Recommendation Report for Planning Permission for Works or Extension to a Dwelling

REF NO: FP/139/20/HH

LOCATION: 21 Middleton Road
Felpham
PO22 6BL

PROPOSAL: Part single storey & 2 storey rear extension, side first floor roof & front porch extension.

PROJECT TITLE	DRAWING TITLE	NEMA DESIGNS LTD email - info@nemadesigns.co.uk	SCALE	DATE
			AS SHOWN	JUN 20
			DRAWING No. PL07

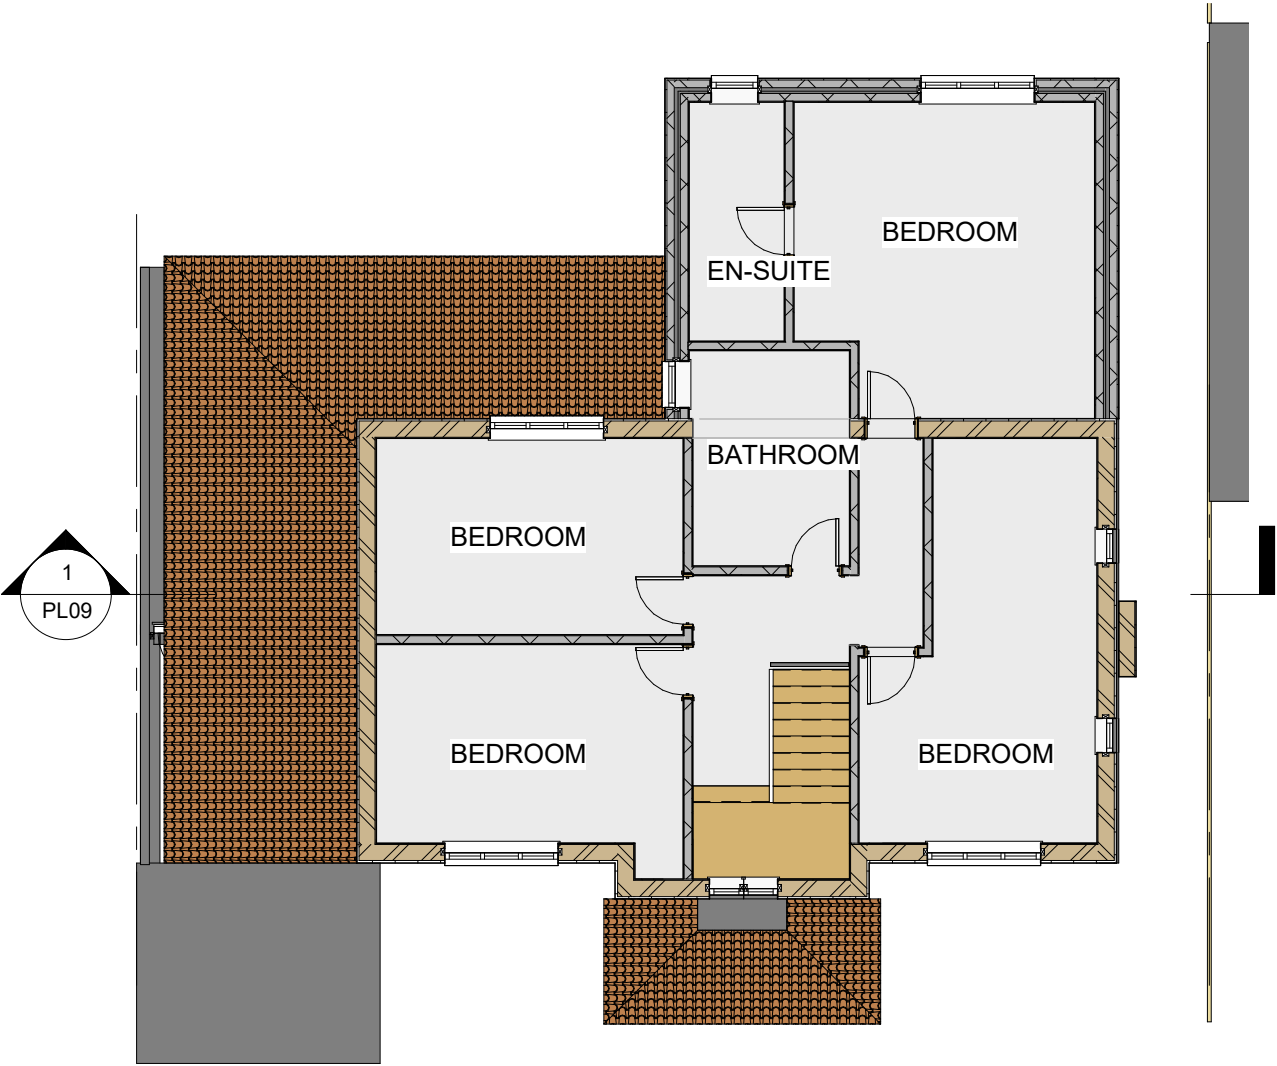
There will be 2 windows to the first floor rear addition replacing existing rear windows, however they sit further in depth to the rear garden. Due to their siting, they are not considered to result in adverse overlooking, additional to that which is already achieved.

There will be an additional window to the western side of the two storey addition which serves a bathroom. Due to the siting this could give direct views towards the neighbouring property and it will be conditioned to remain obscured glazed to prevent adverse overlooking.

- 3 The first floor window on the western elevation of the building shall at all times be glazed with obscured glass and only openable at a high level, at least 1.7m above finished floor level.

PROJECT TITLE PROPOSED PORCH & EXTENSION 21 MIDDLETON ROAD, FELPHAM BOGNOR REGIS, PO22 6BL	DRAWING TITLE PROPOSED ELEVATIONS	NEMA DESIGNS LTD email - info@nemadesigns.co.uk	SCALE AS SHOWN	DATE JUN 20
			DRAWING No. PL08

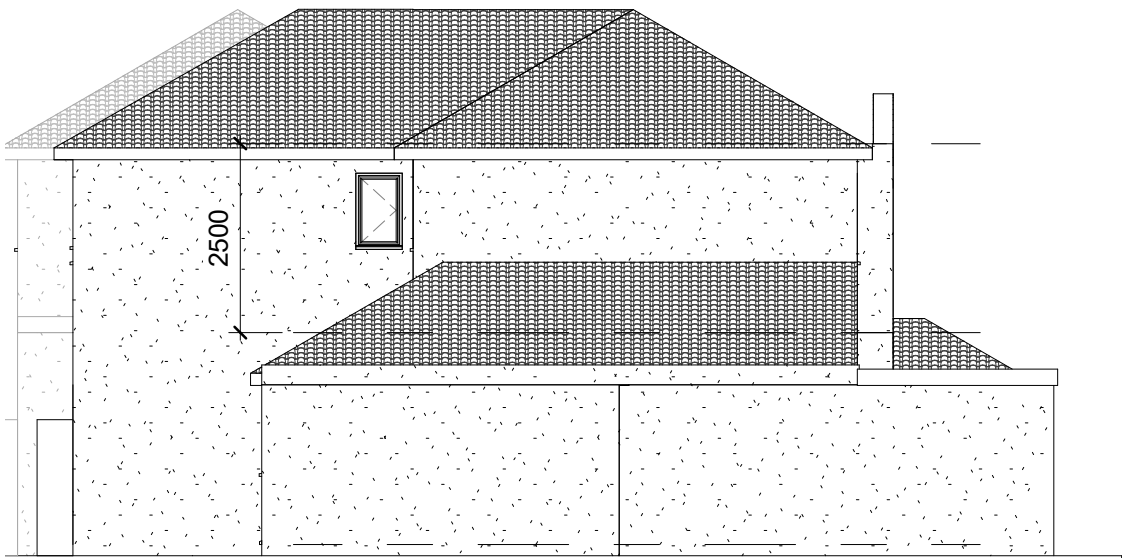
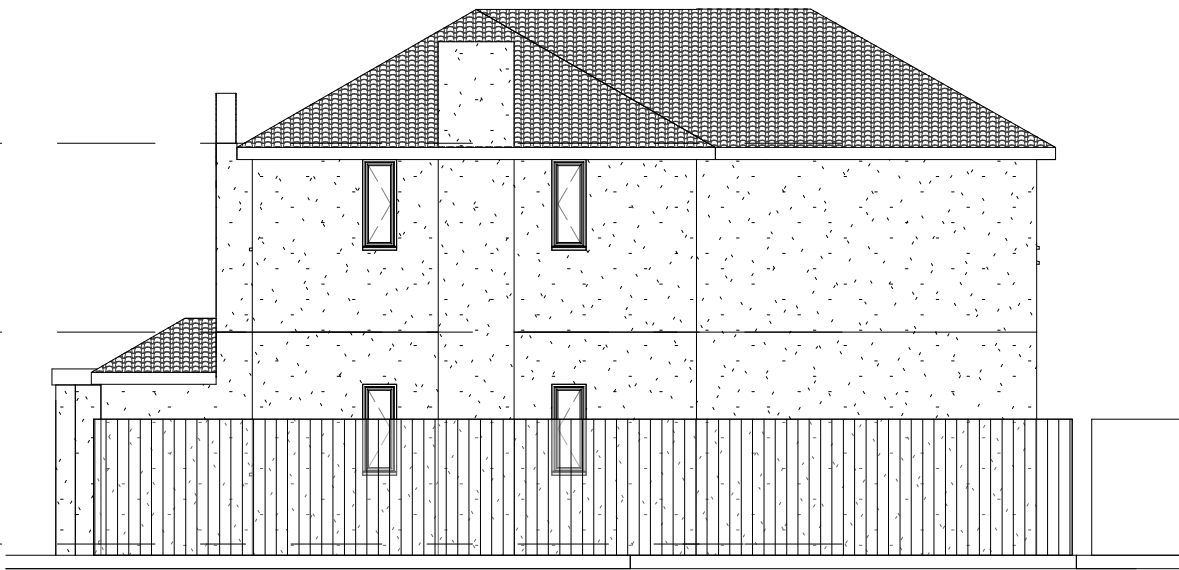
The porch will have a depth of 2m and a width of 3.4m. It will have a hipped roof which matches the design of the host dwelling. This retains around 12m to the front boundary which consists of fencing around 1.7m in height and therefore views are largely restricted and the development does not appear as an unduly dominant feature upon the front elevation.

The two storey extension will be situated to the north eastern side extending in line with the side elevation. It will have a depth of 4.5m and a width of 6m along the rear. It will have eaves to match the height of host dwelling with a hipped roof. This will then reduce to single storey although the depth will reduce to 2m and extend along the remaining rear meeting with the side elevation of the dwelling and rear of the garage.

The single storey addition will have an eaves height of around 2.4m and will have a lean to roof which will also extend along part of the flat roof garage, to a height of around 3.7m. This will run along the boundary however due to the modest depth and with the roof sloping away from the boundary is not considered to result in significant overbearing or overshadowing impact.
